**Application by SP Manweb for an Order Granting Development Consent for the Reinforcement to the North Shropshire Electricity Distribution Network**

**Canal & River Trust Response additional submission for deadline two**

**Written question from examining authority – Q9.0.1**

Document Title: CHAPTER 6: LANDSCAPE AND VISUAL FIGURE 6.7 VIEWPOINT LOCATIONS PAGE 1 OF 5

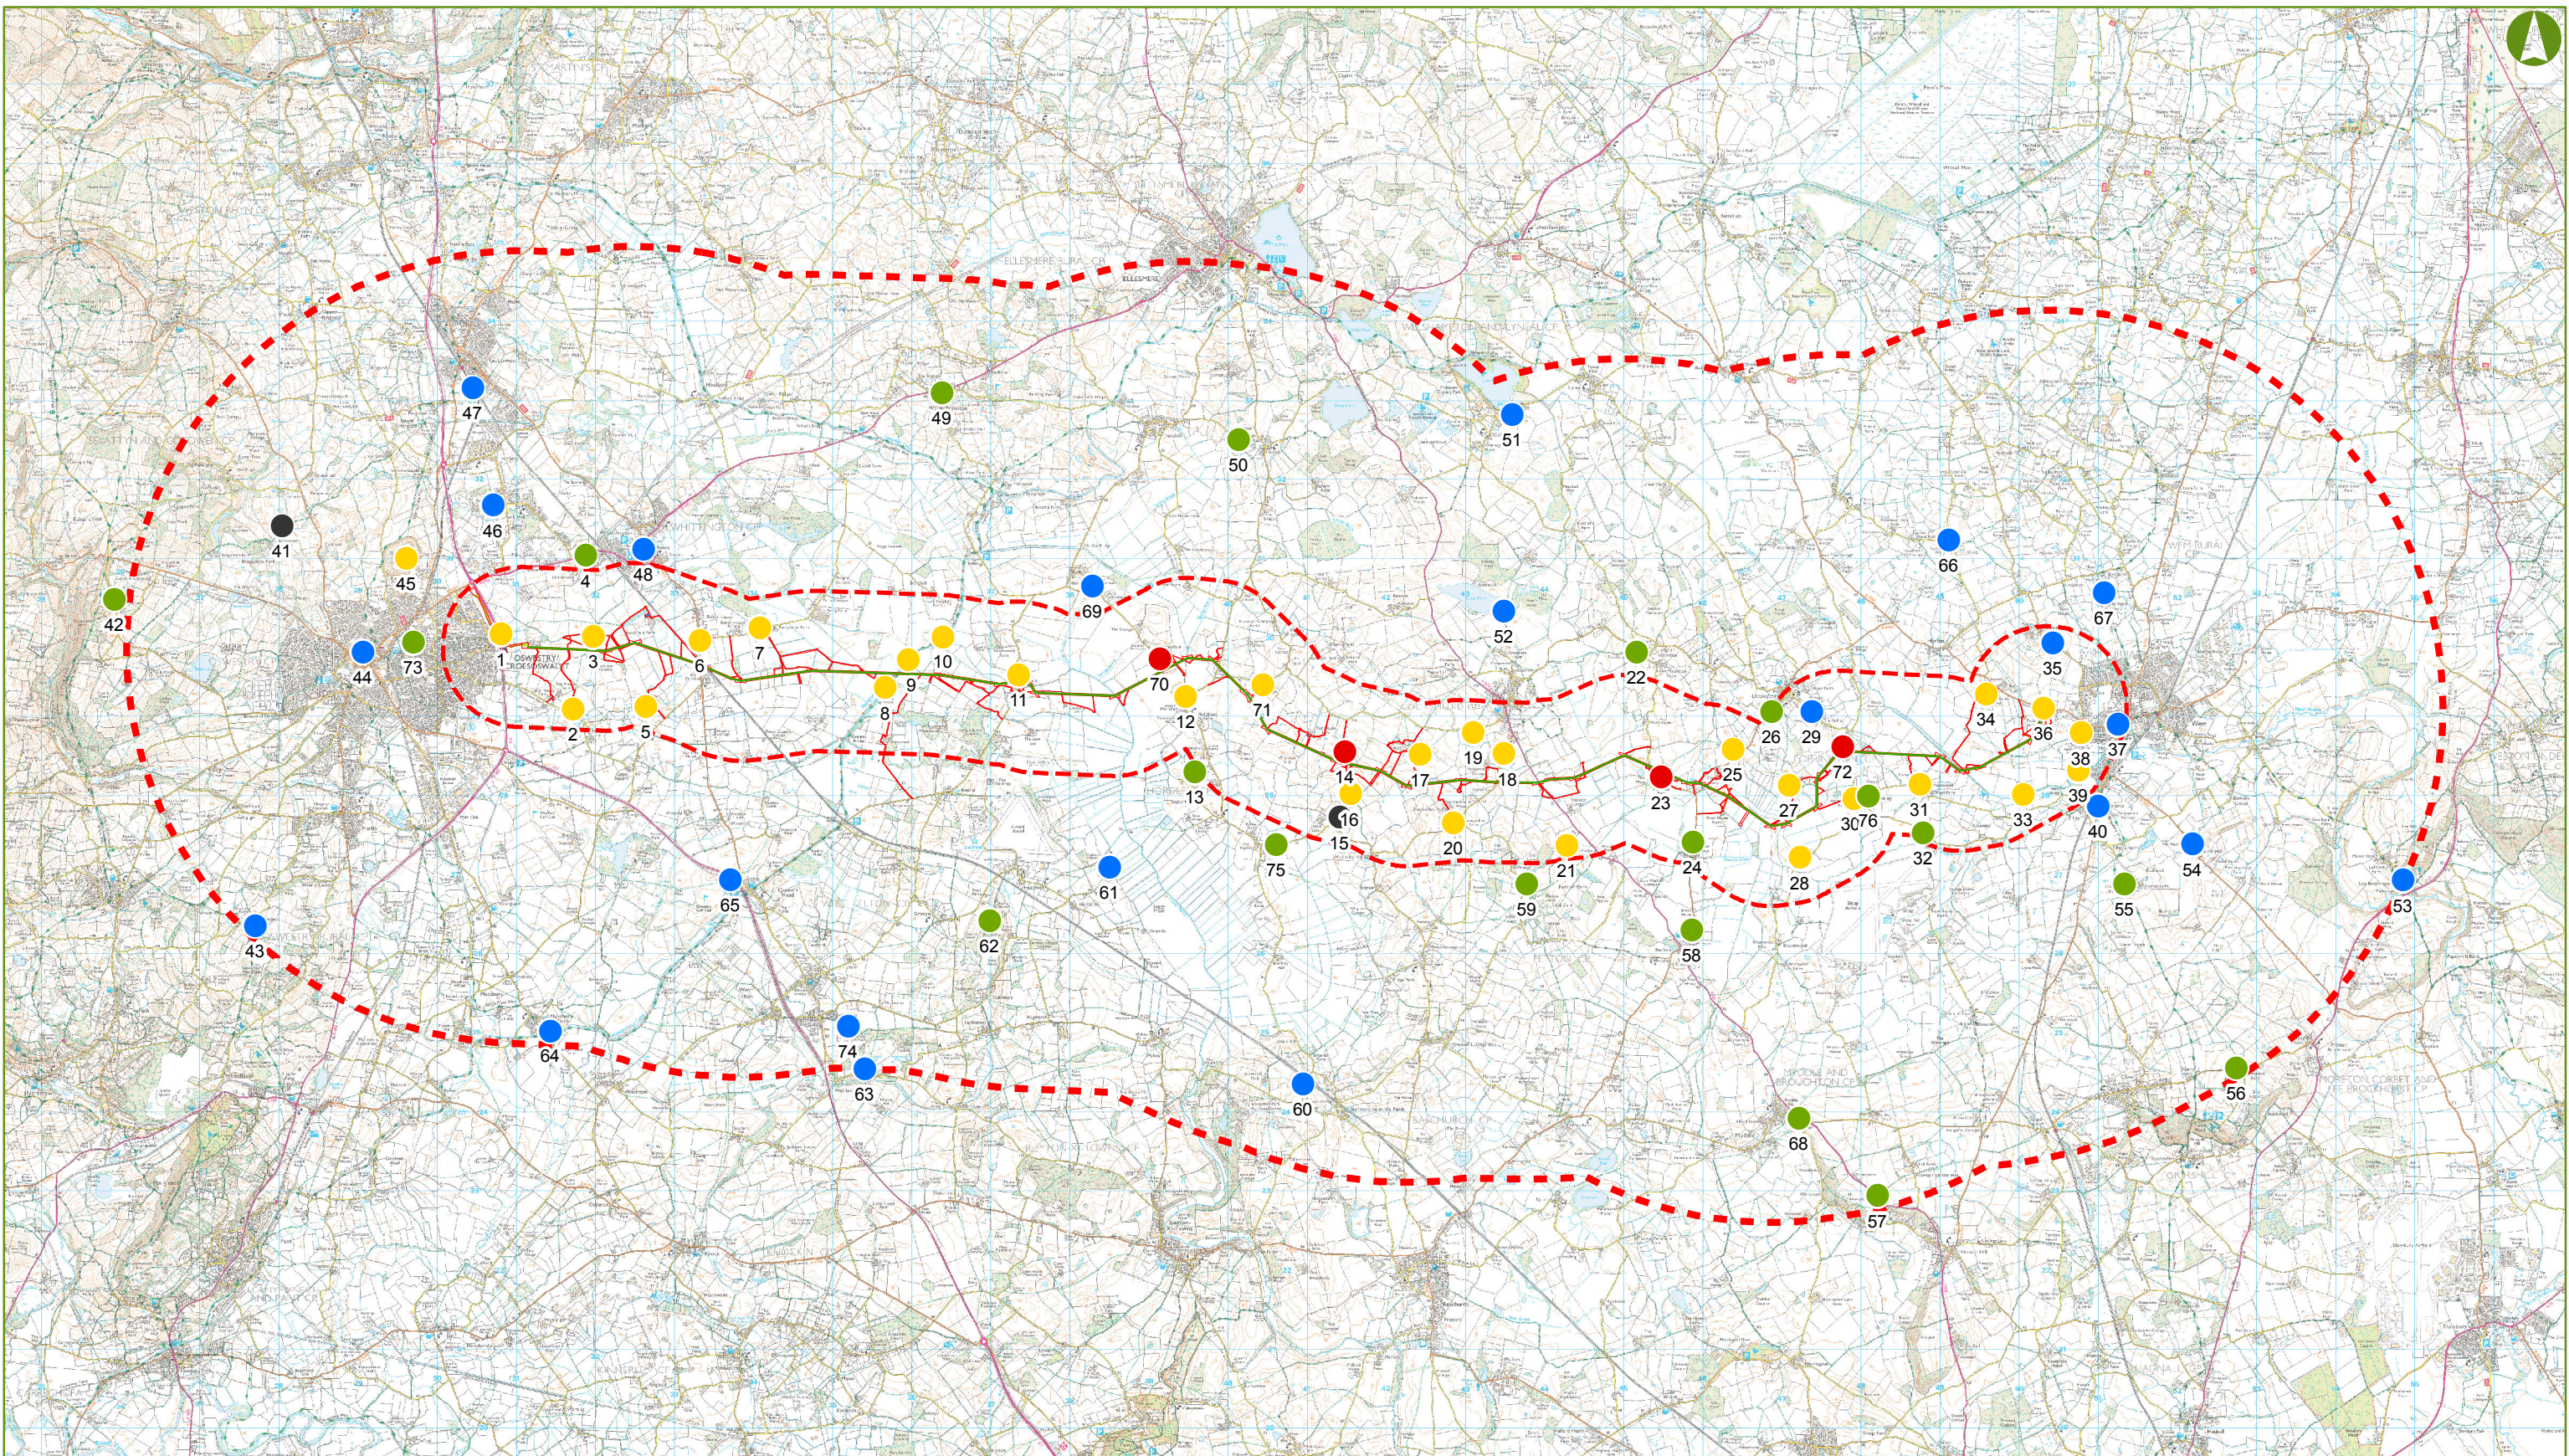
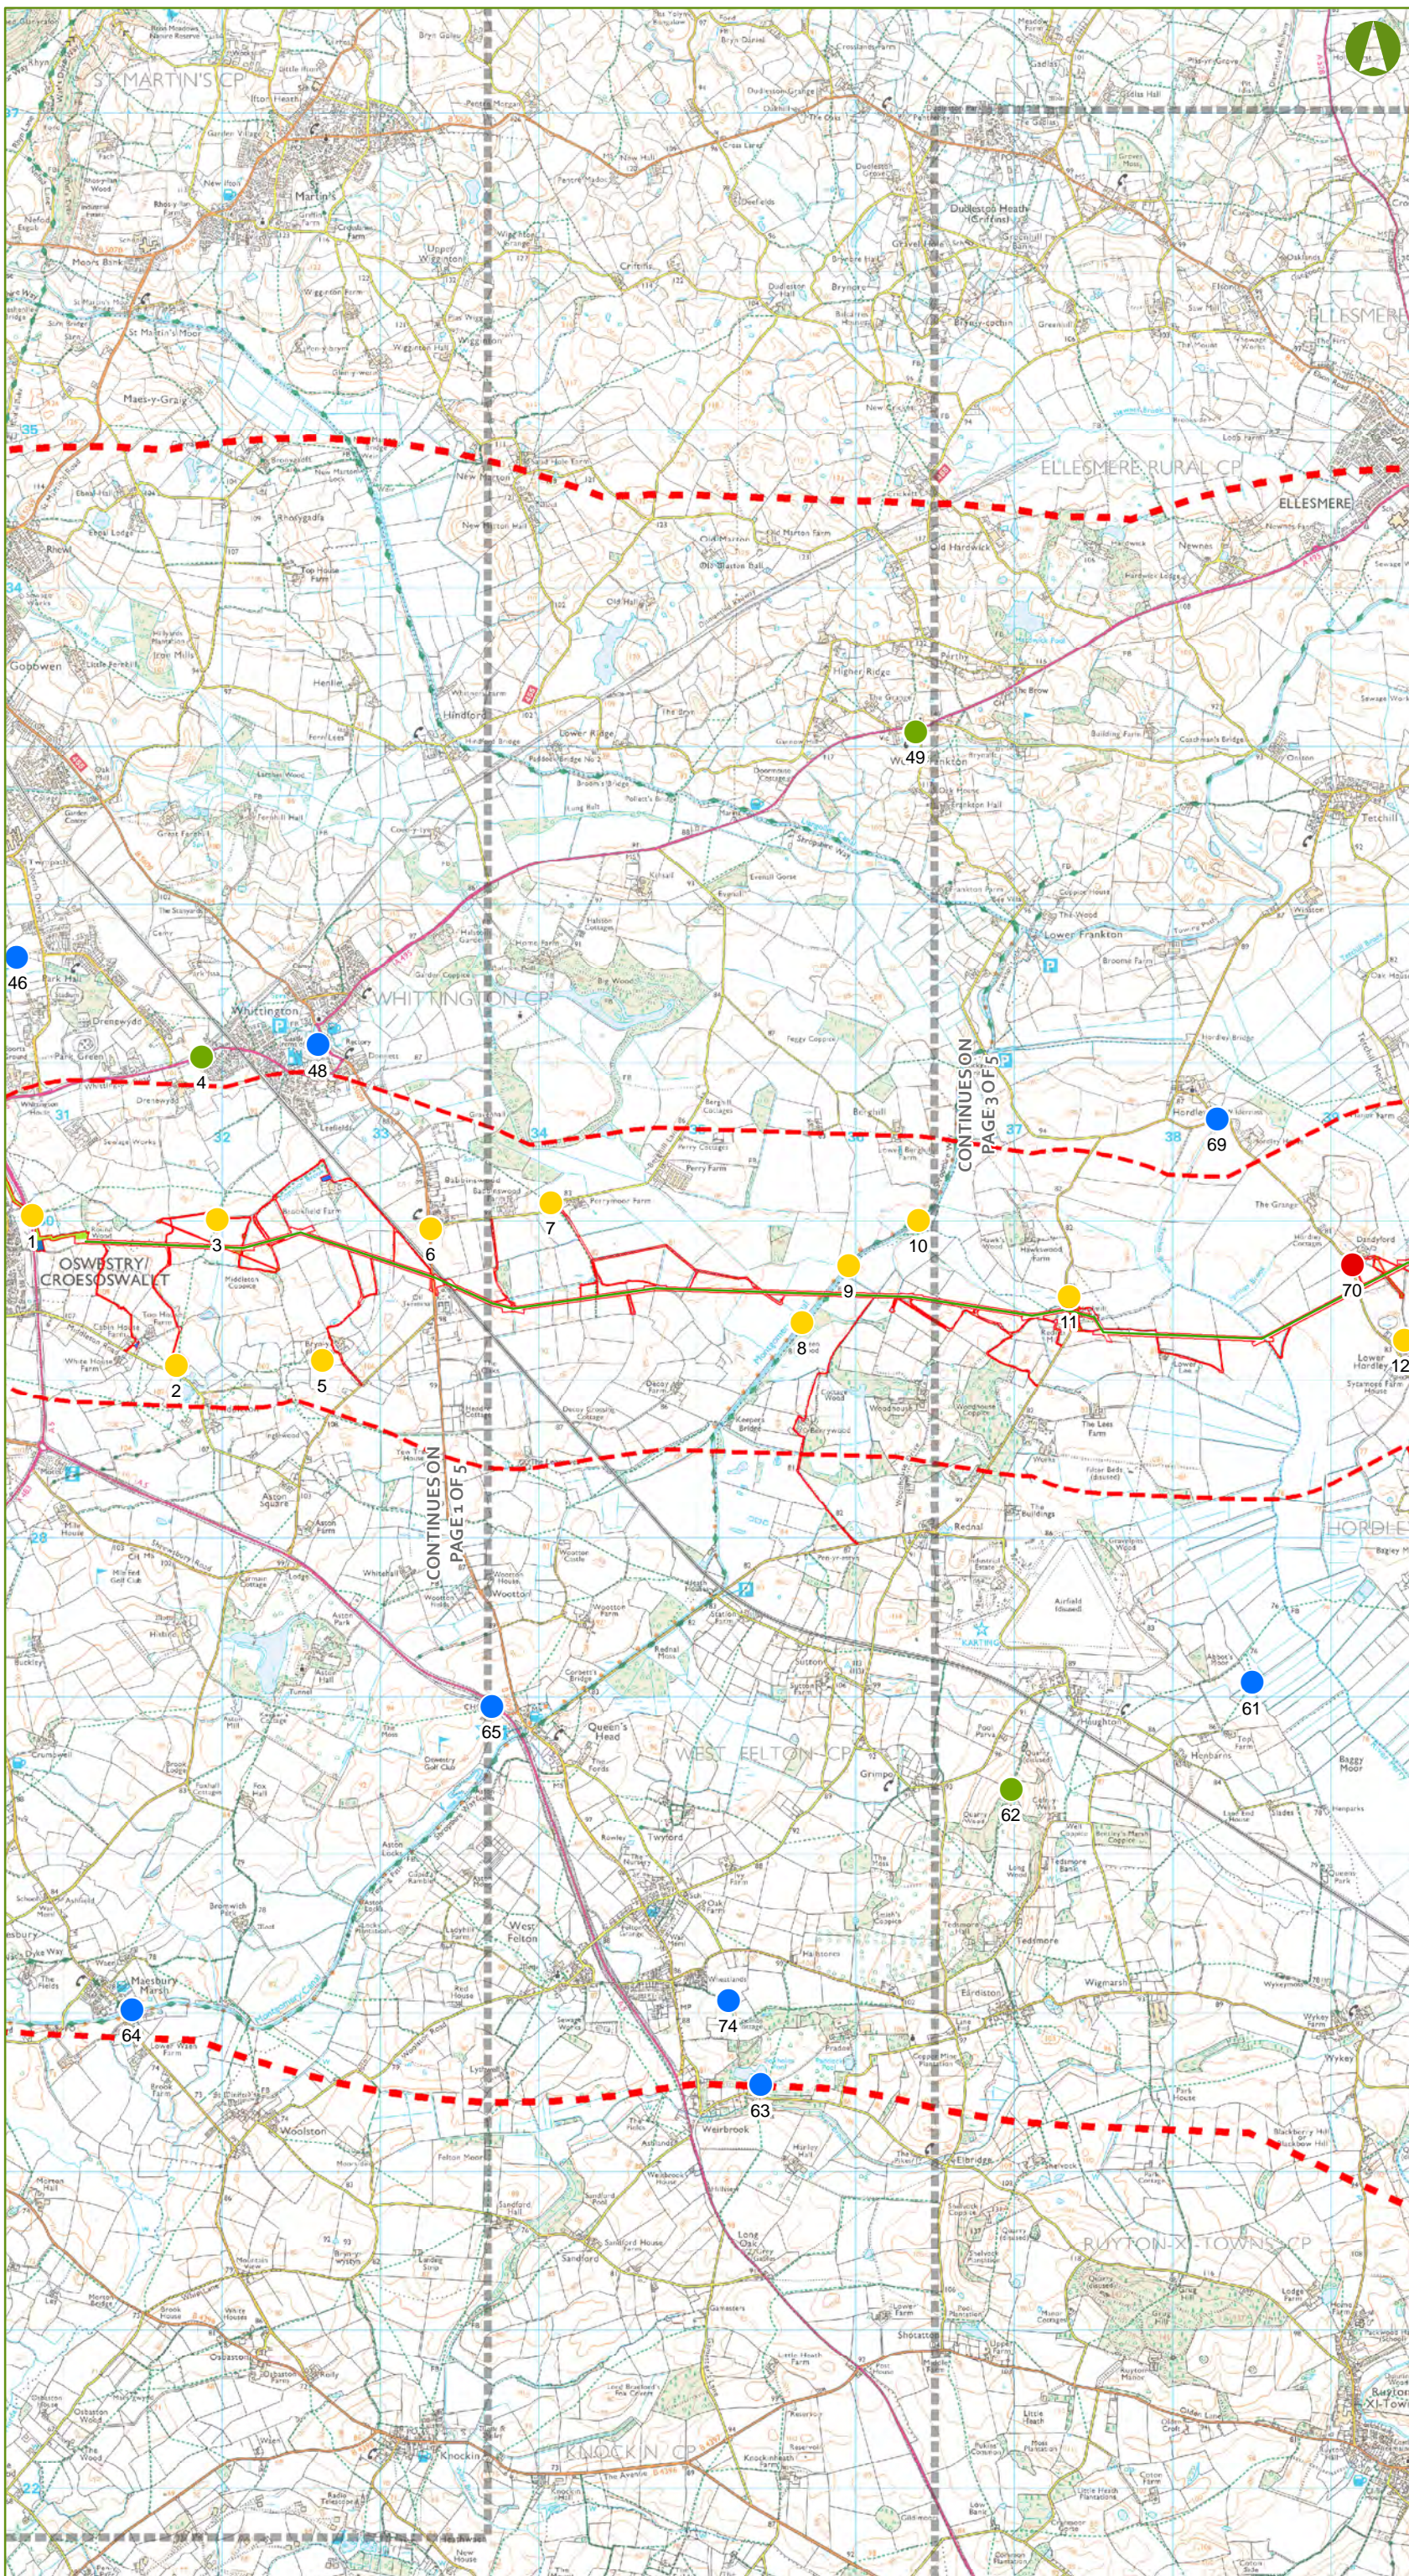
The LVIA document itself is relatively generic and sets out the methodology for assessing impacts. We consider that the methodology used is appropriate. We generally agree the findings of the LVIA in terms of the impact on the canal, insofar that it assesses the overhead line at viewpoints 8, 9 and 10 and assesses the impact from these points as being of 'minor significance'. However, the Trust are unable to agree to the findings of the LVIA in totality, as we would like to see further assessment of the visual impact from underneath the lines where it crosses the canal. As stated at Table A6.3.5 of Appendix 6.3 (page 81), at the point the line oversails the canal the magnitude of change would be medium and effects on visual amenity moderate adverse (i.e significant). We consider that this justifies a further viewpoint/photomontage being provided from underneath the lines where it crosses the canal. This would enable a full assessment of the impact to be undertaken and for the required mitigation to be identified. This in turn may require the viewpoint to be considered amongst the sites assessed at Table 6.4 of the LVIA and conclusions of the LVIA at paragraph 6.9.3.

In the absence of the above viewpoint, the Trust do not agree to paragraph 6.8.2 of the LVIA and the applicants assertion that no mitigation is required. As acknowledged by the applicant, there would be an impact at the point the line crosses the canal, which requires full further assessment to identify whether mitigation is required.
